From: Emma Kirkman
Sent: Thursday, 6 December 2018 3:22 PM
To: Scott Hay
Cc: Media Hakim
Subject: SSD 9210 Saints Peter and Paul Assyrian Primary School EIS

On 5 November 2018, the Department of Planning and Environment invited GANSW to review and provide comment on the development application, including the Environmental Impact Statement, for the Saints Peter and Paul Assyrian Primary School. The project was presented to the SDRP on 13 June and again on 11 July. The outcomes of these reviews were incorporated in design advice provided to the proponent. The review of the EIS is made in relation to that advice. We remain supportive of the proposal, subject to additional comments below.

Landscape Master Plan

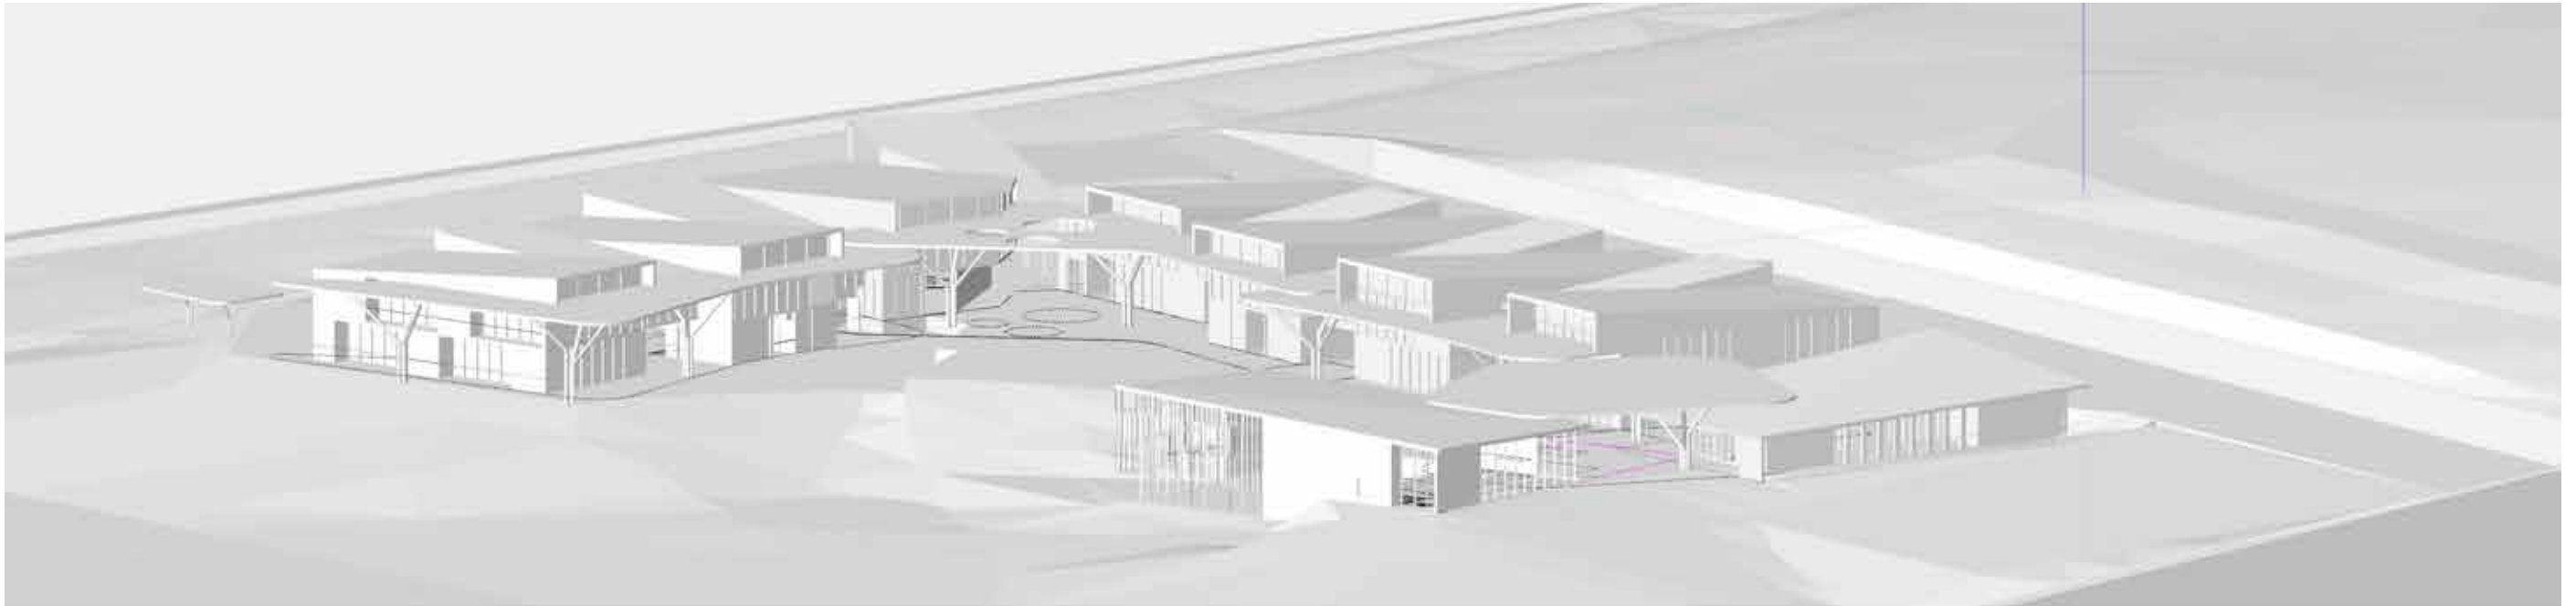
- The landscape drawings indicate a proposed tree planting schedule but we request numbers be provided to determine if the proposal meets the NSW Urban Tree Canopy Targets (40%).

01 Section
A352 Roof Connection
Scale 1:50

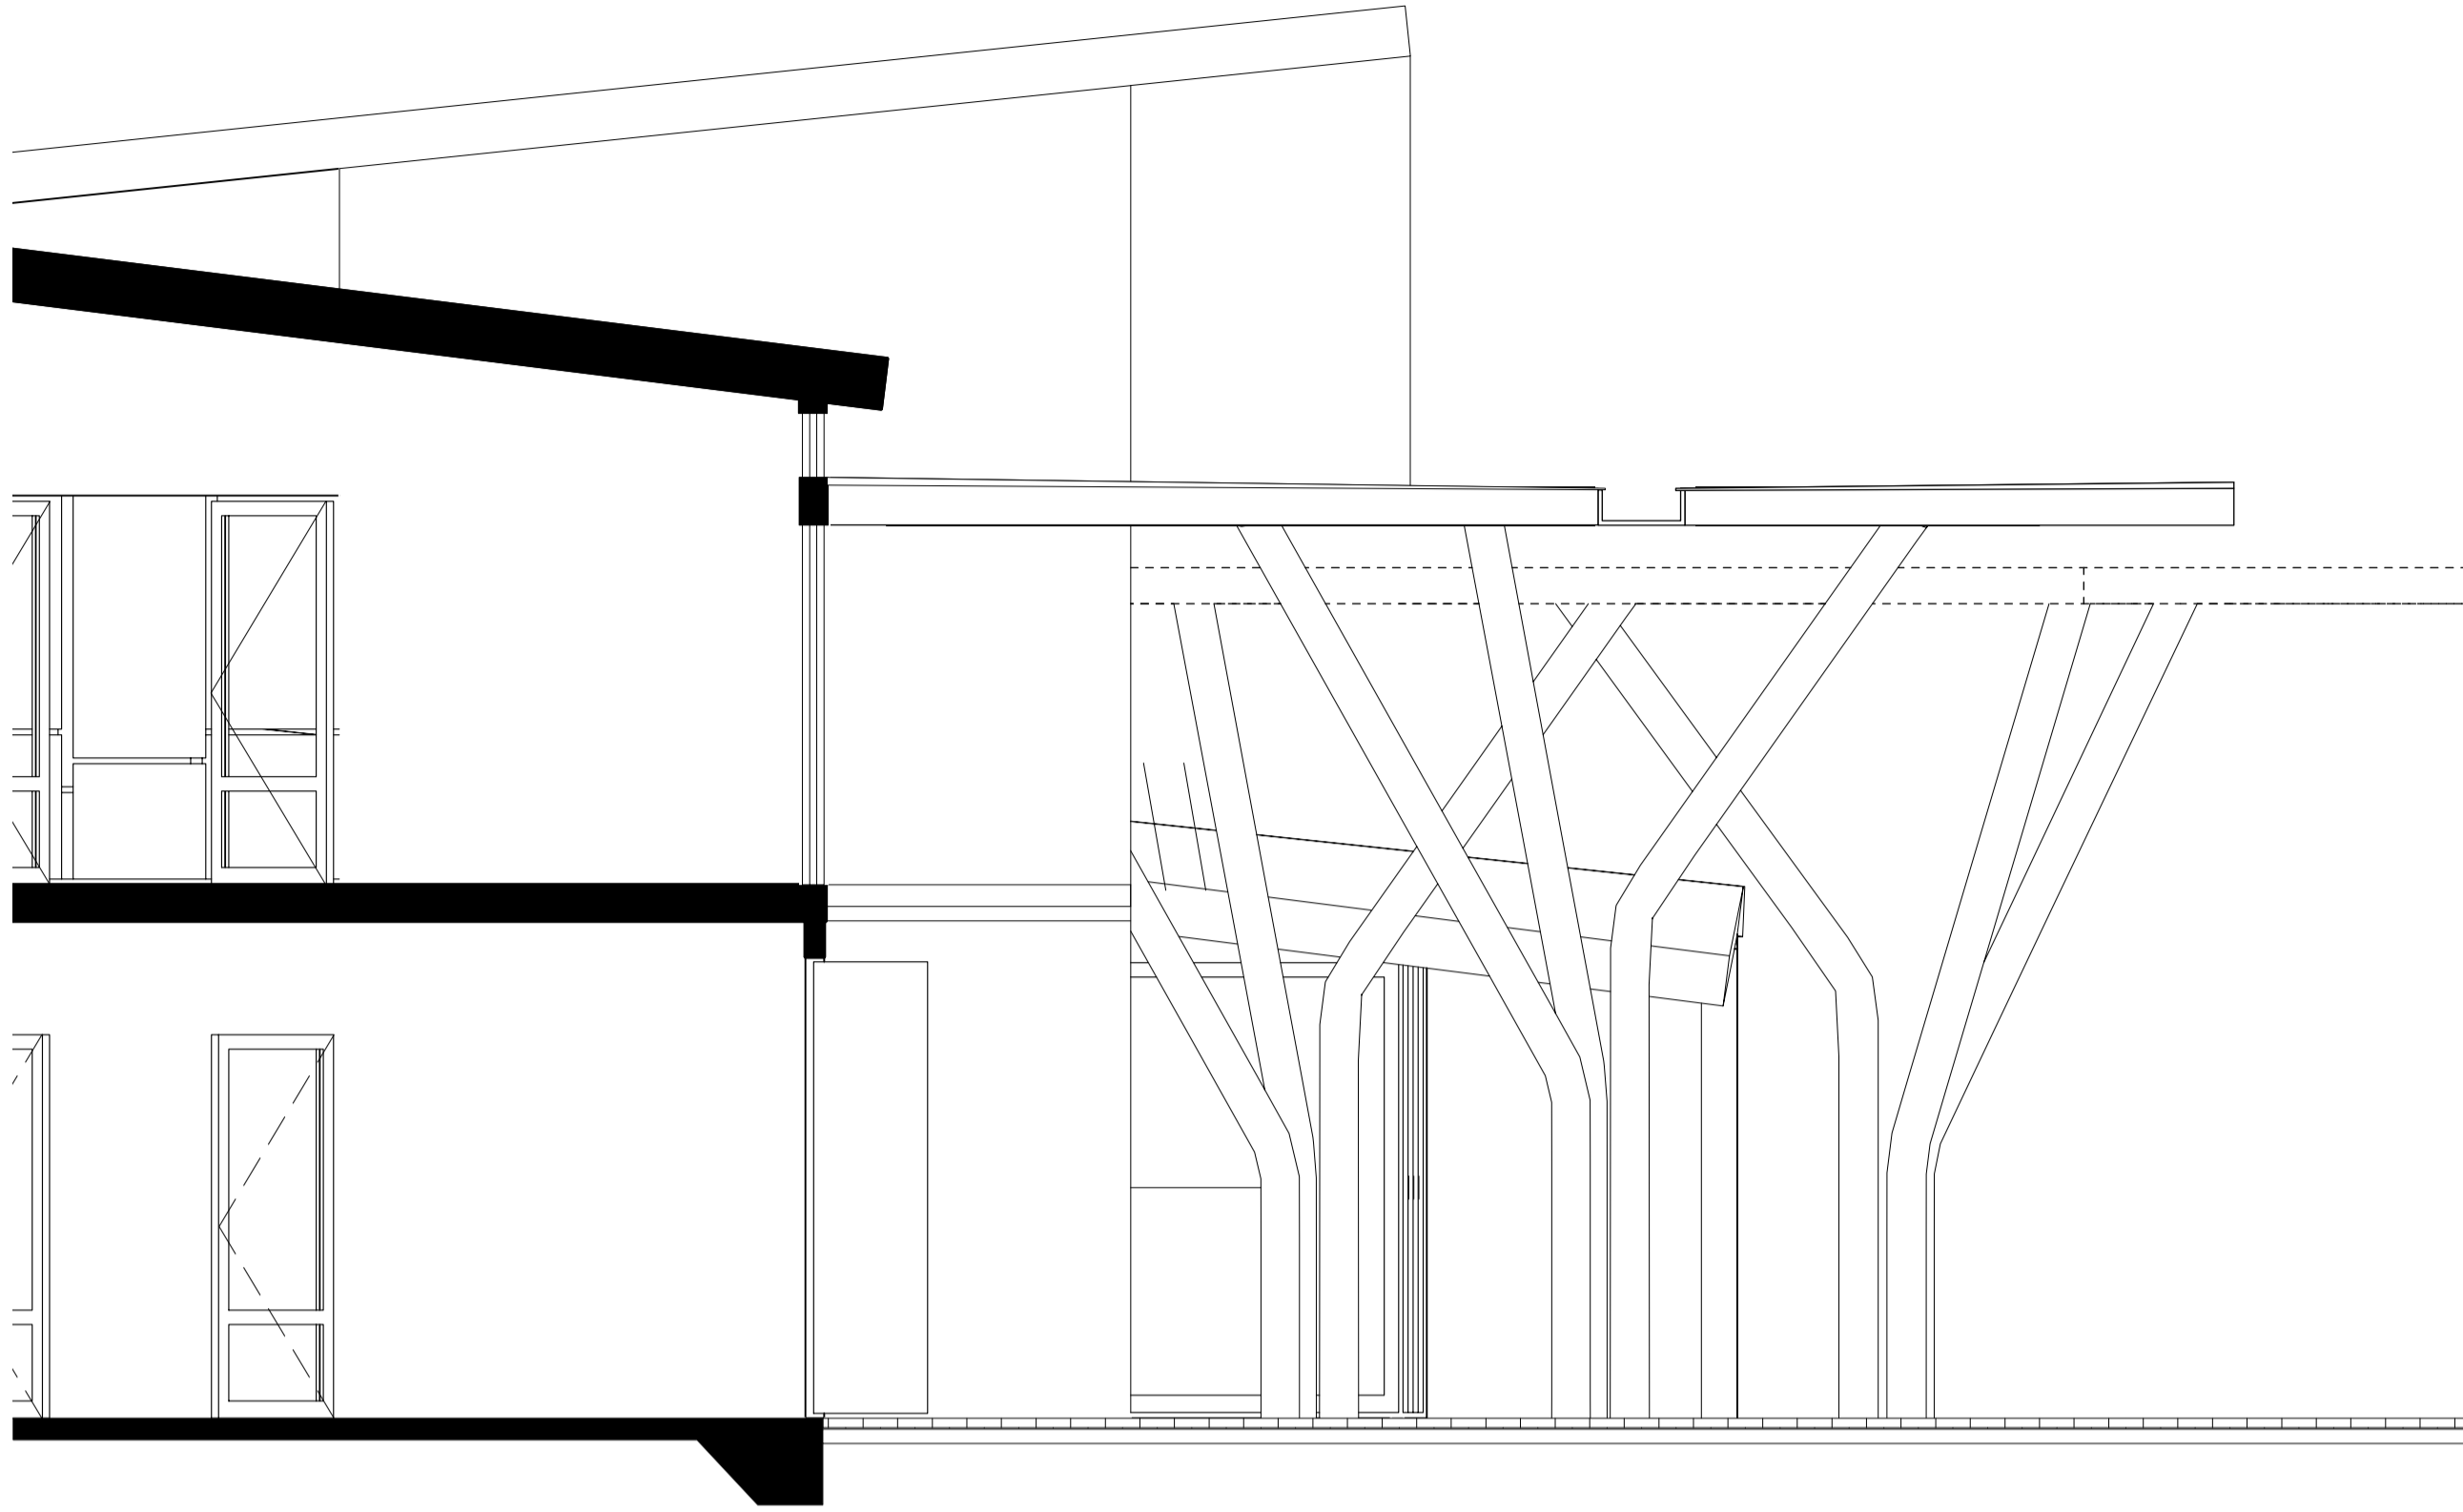
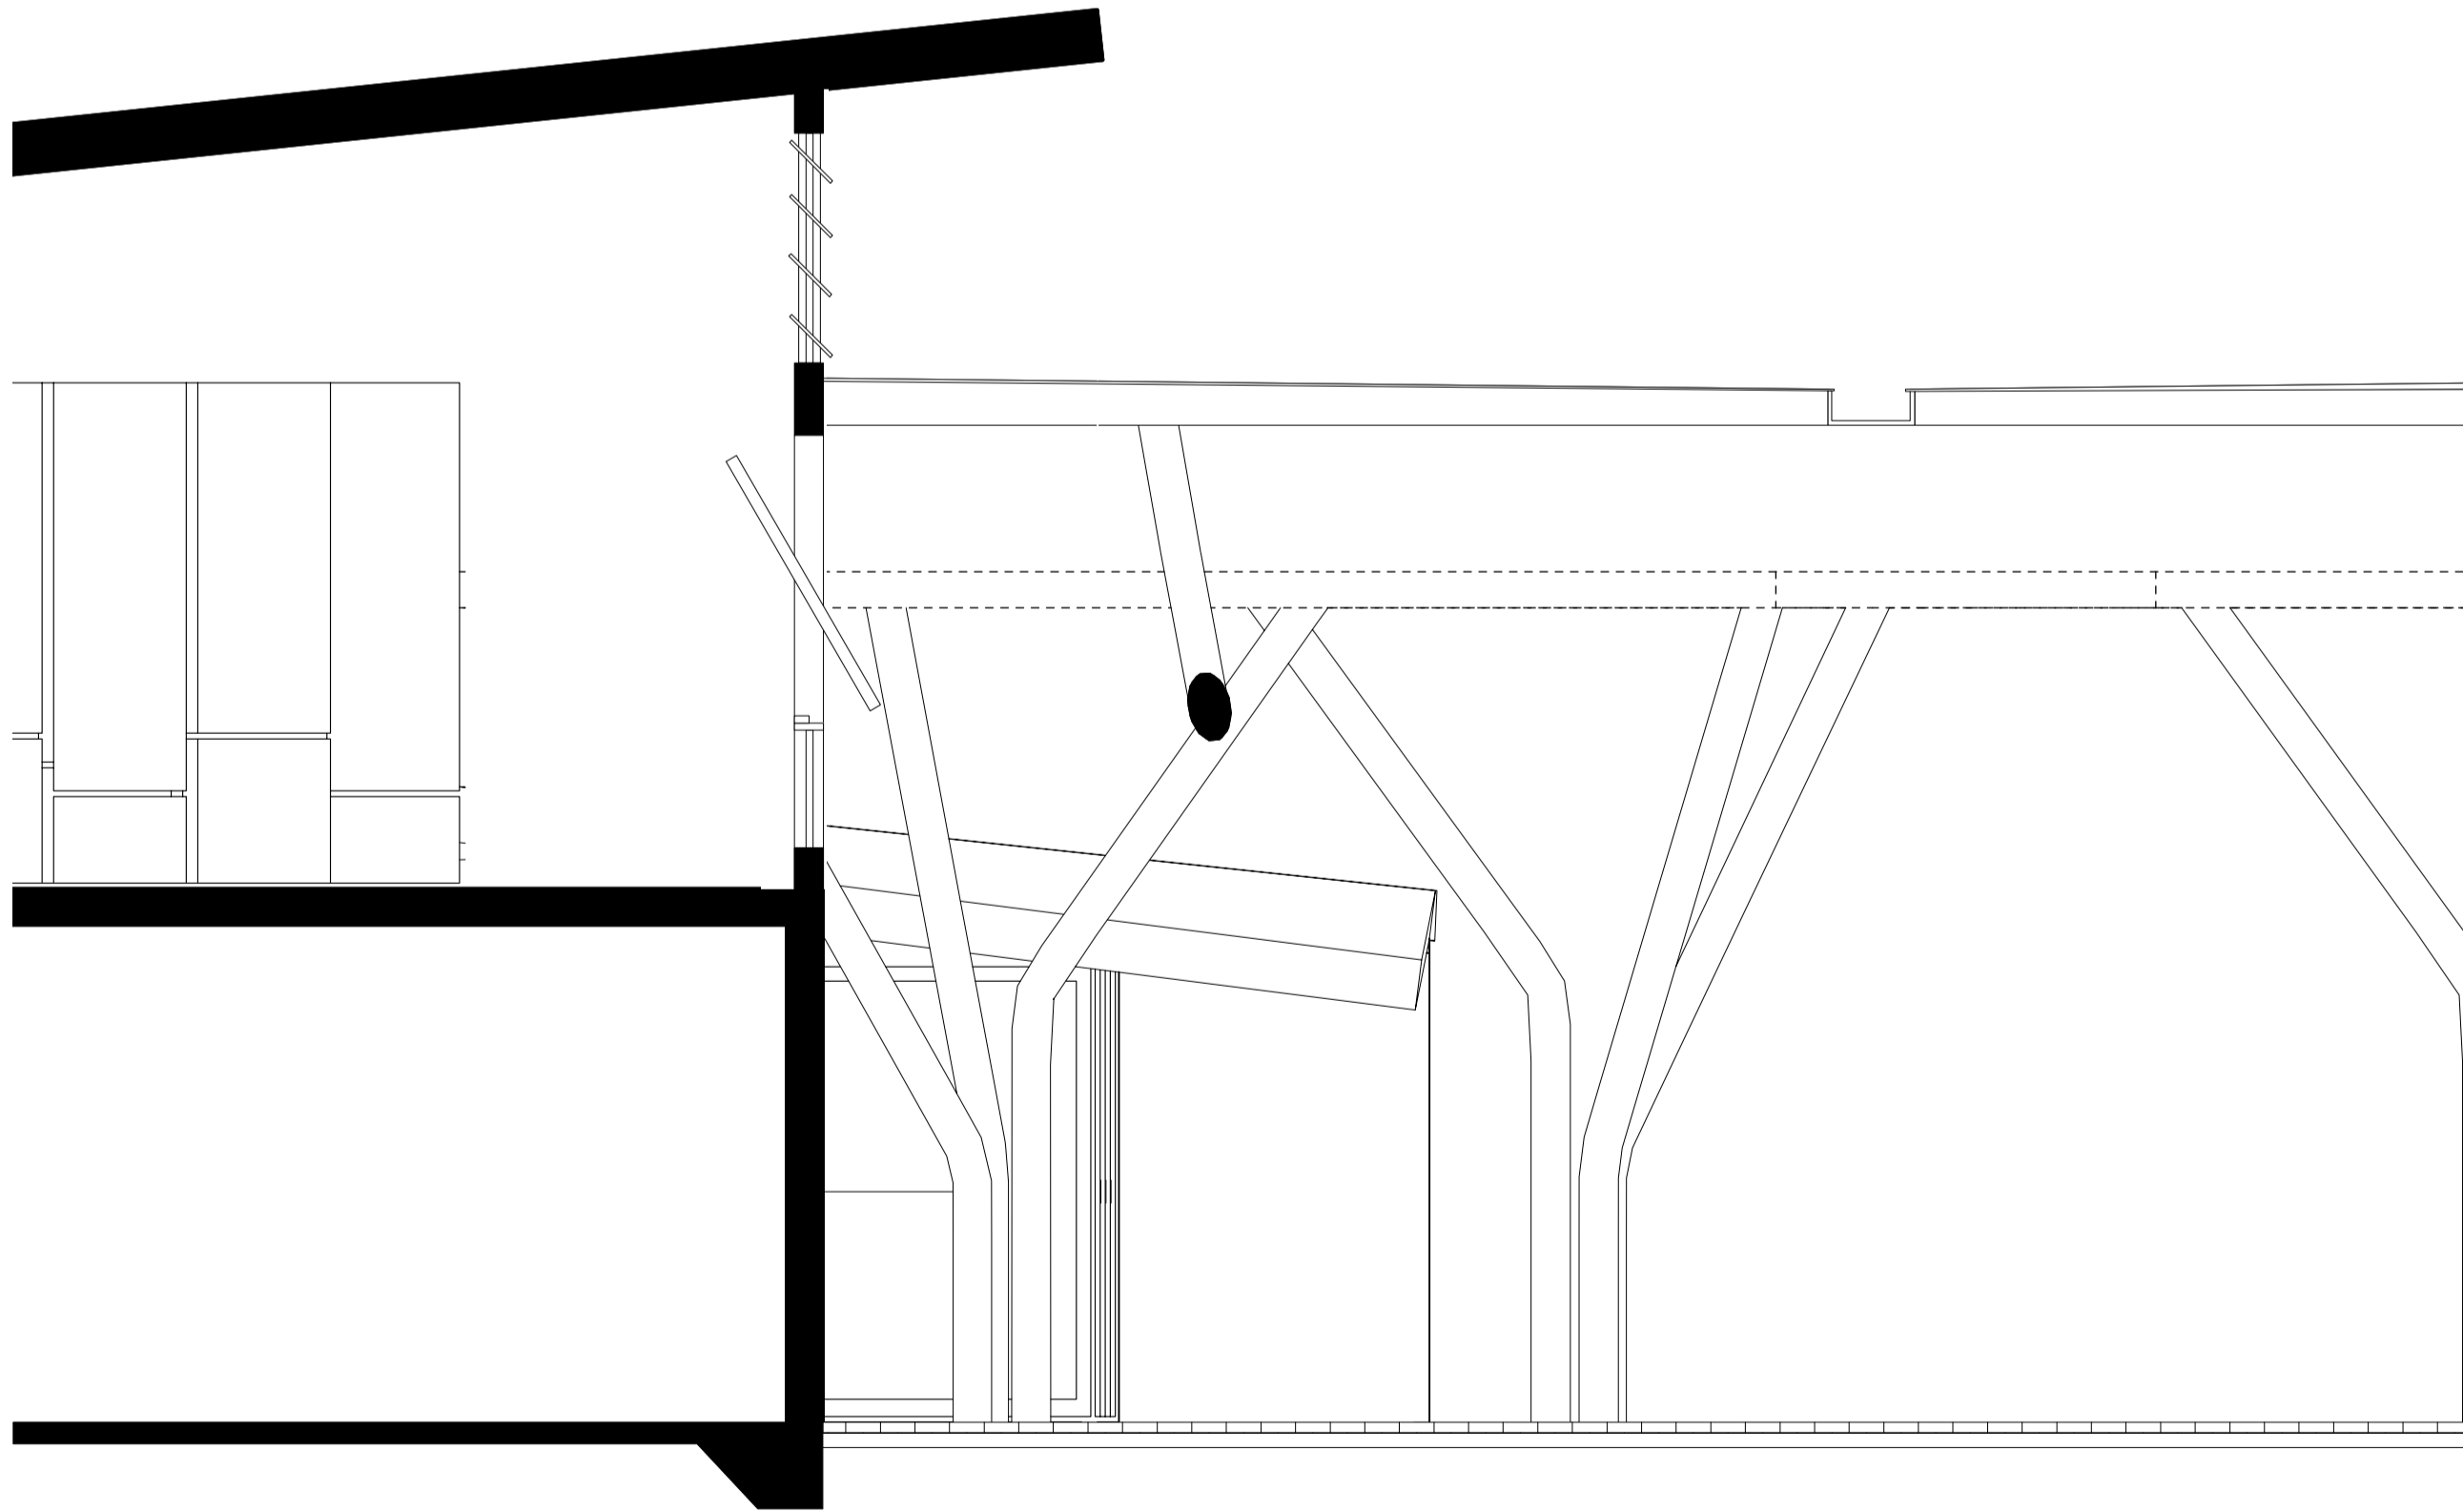
- While the design report states that solar and glare controls have been integrated into the façade design, we request larger scale drawings which show what these controls are and where they're used on the façade.
- We recommend larger scale drawings showing the detailed resolution of the skillion roof form, and heights and relationship to buildings of the canopy roof form.
